Re: Wal-Mart at 4700 Cutler, Administrative Amendment Request, Project #PR-2021-005016

Please find responses below in bold addressing the Transportation Development Comments received March 10, 2021.

DEMOLITION & SITE PLAN  
SHEET: CS1

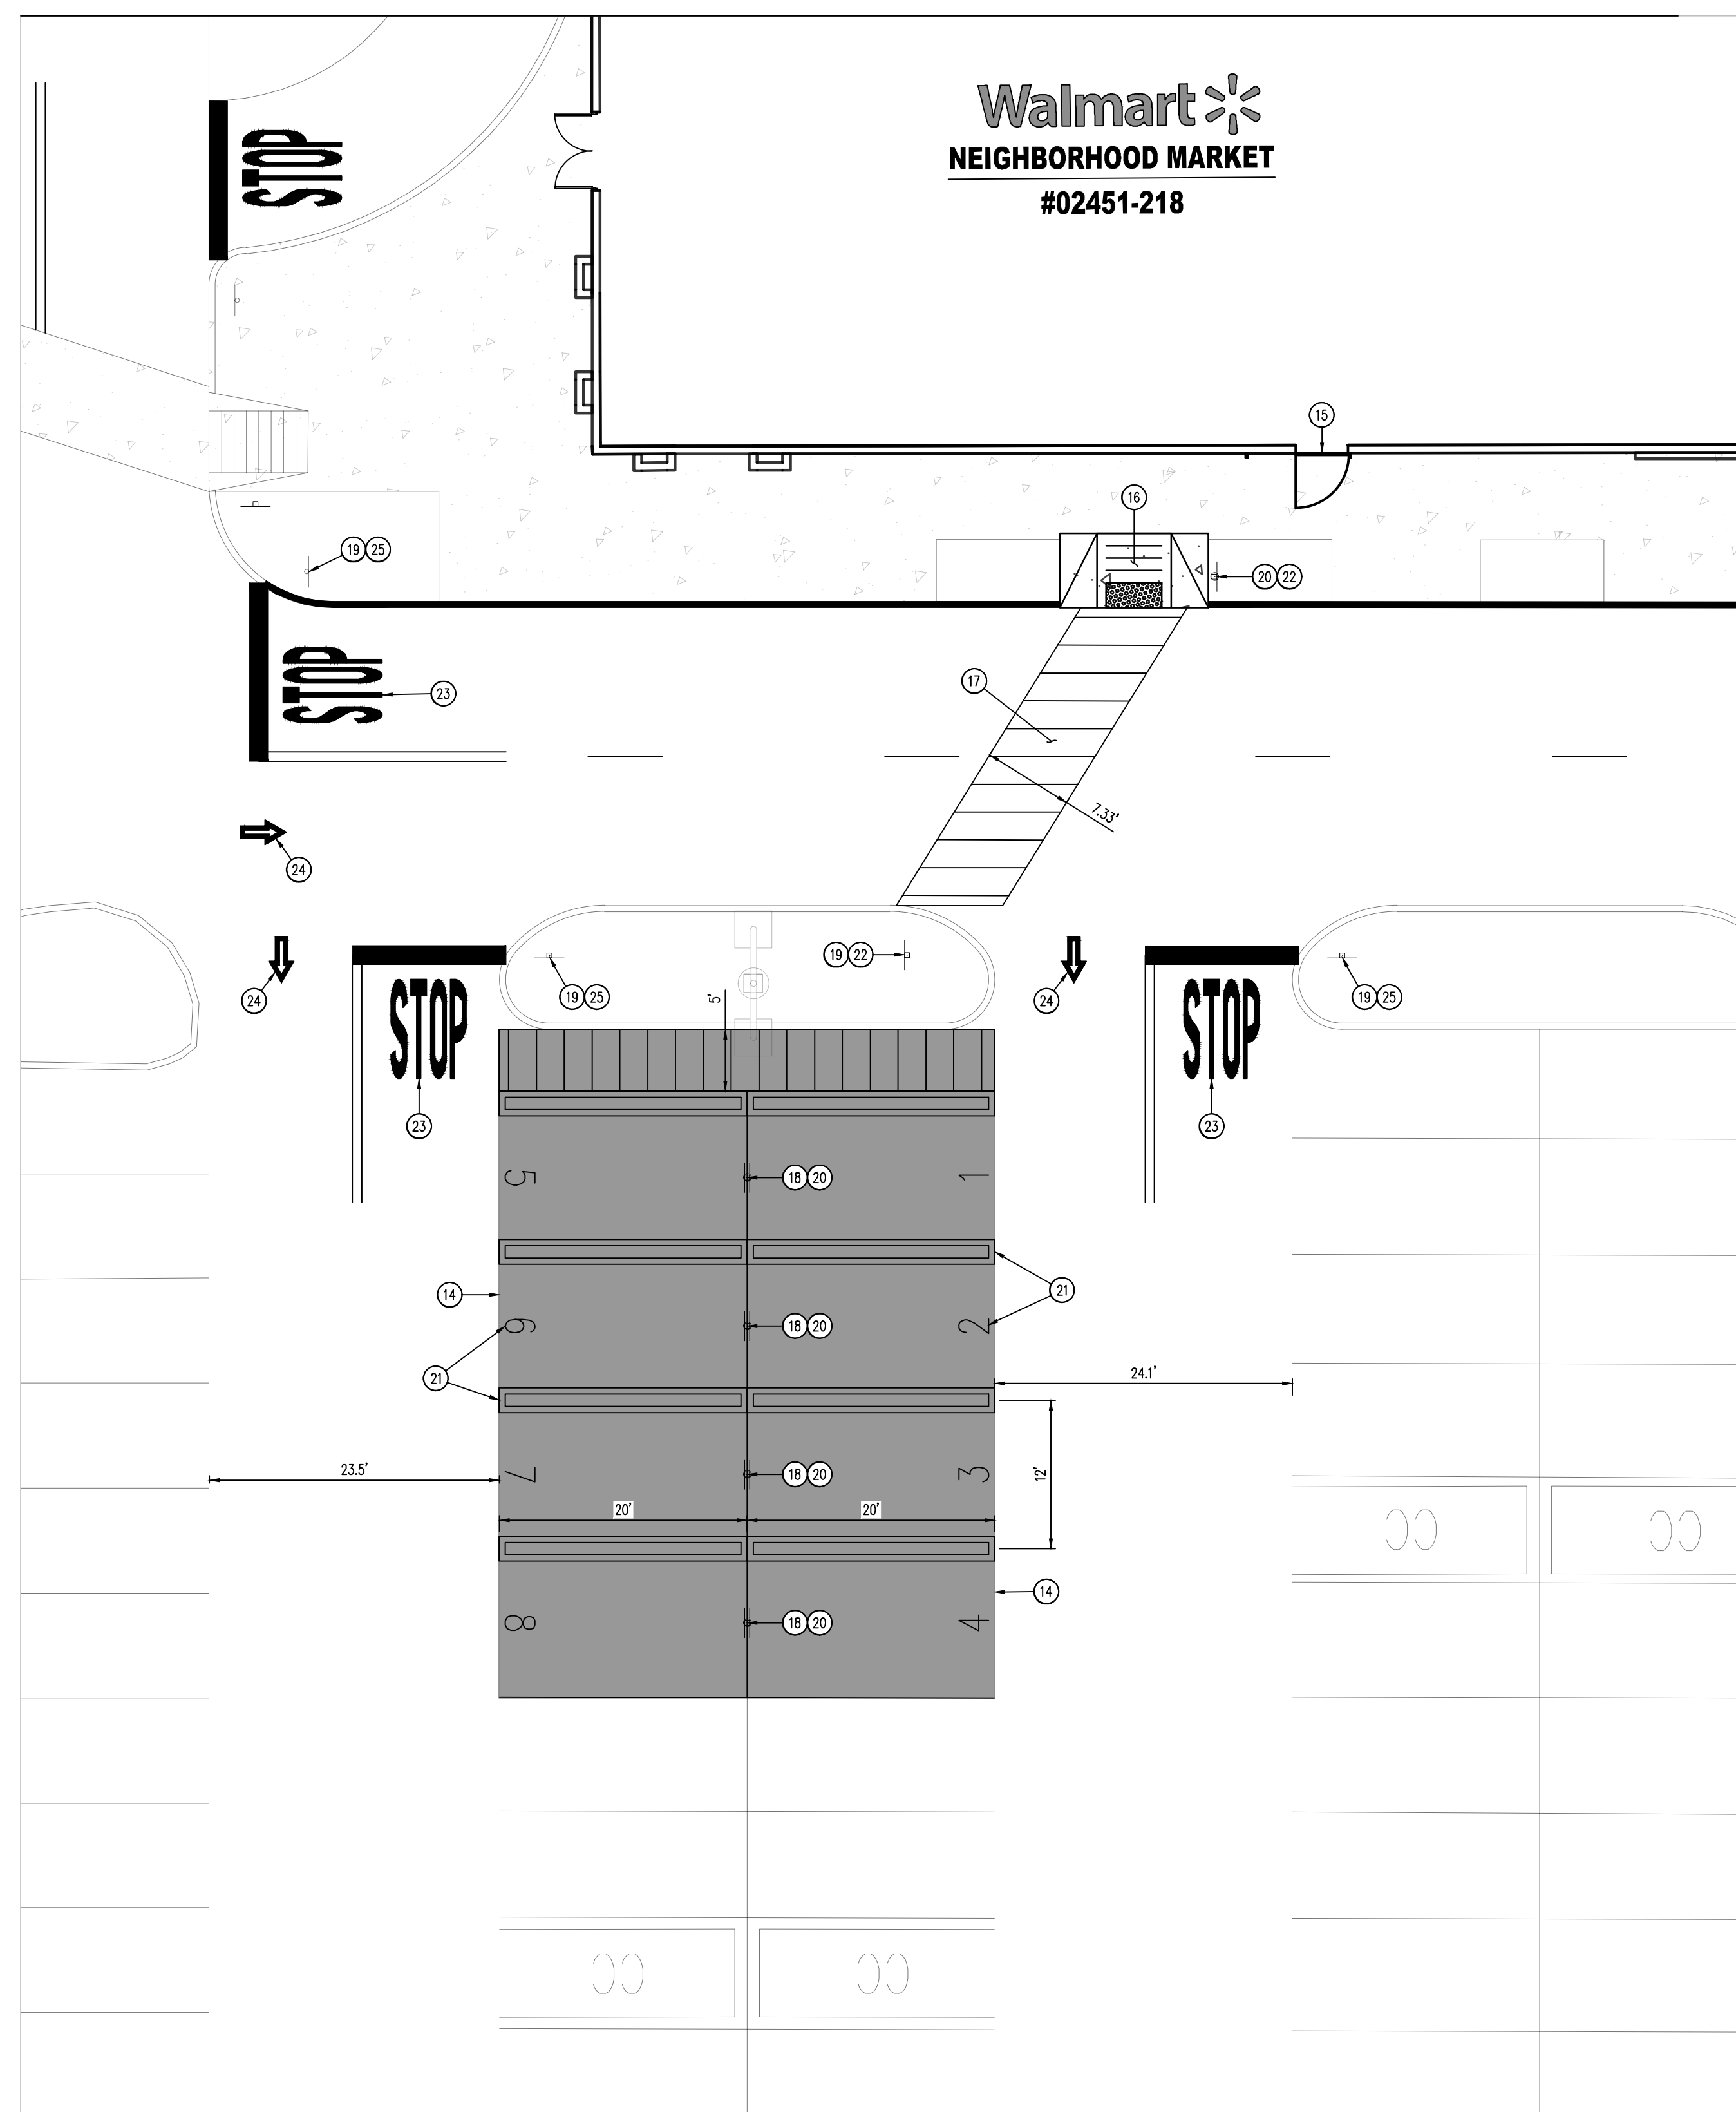
1. For the truncated domes specified a a 2-foot width next to the street instead of 3 feet.

2. On CS1, you have note 24 listed twice in the keyed note section when I think for Note 25, you meant for that to be a stop sign. (You can just switch out this one sheet).

Response: The truncated domes in the curb ramp has been revised on sheets CS1, SECP-1 and SECP-2, ref included documents.

Response: The schedule note has been revised to correctly indicate "25".
